Application No: AL/141/21/RES
Site Address: Land North of Lee's Yard Lidsey Road Woodgate PO20 3SU
Description of works: Approval of reserved matters following outline planning permission AL/21/20/OUT for the approval of the appearance, layout, scale and landscaping for 5 No 4-bed dwellings, 14 No 3-bed dwellings & 19 No 2-bed dwellings. This site is in CIL Zone 3 and is CIL Liable as new dwellings.

Thank you for your internet representation made on 14th February 2022 which has been recorded as an objection with the comments as follows:

Drawing Name Landscape Strategy

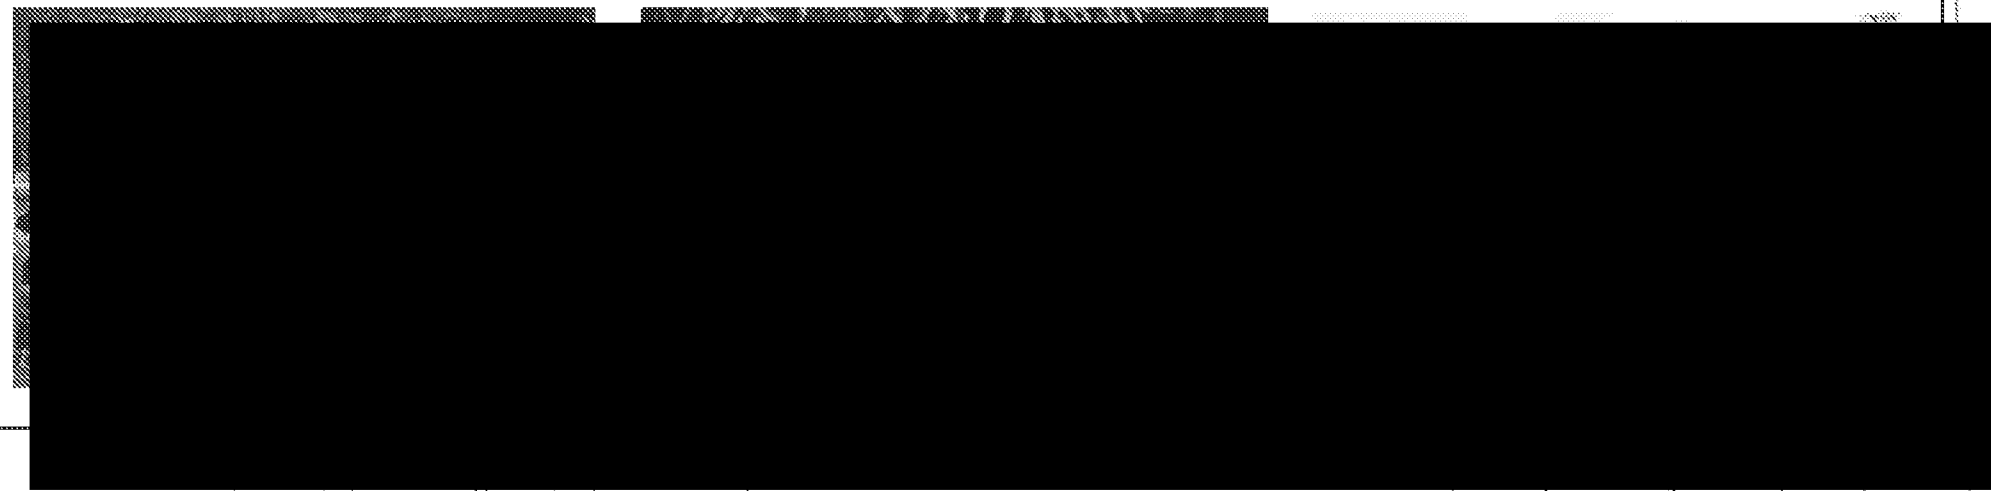
In terms of the design, whilst we can see that the efficient road layout has allowed more community space this has resulted in less effective community space. The original concept was to create a village feel to the design, not yet another standard building site, through locating the community space at the centre of the development.

Moving the open space to the entrance is not conducive to creating a community space. It has cars entering and exiting the site, possibly at speed and we do not see this being a safe space for families and particularly children, particularly compared to the original plans.

There appear to be two large trees that are lost or threatened on the northern part of the site.

In addition, the parking areas located roadside along the northern road creates a very urban feel for the site in this location.
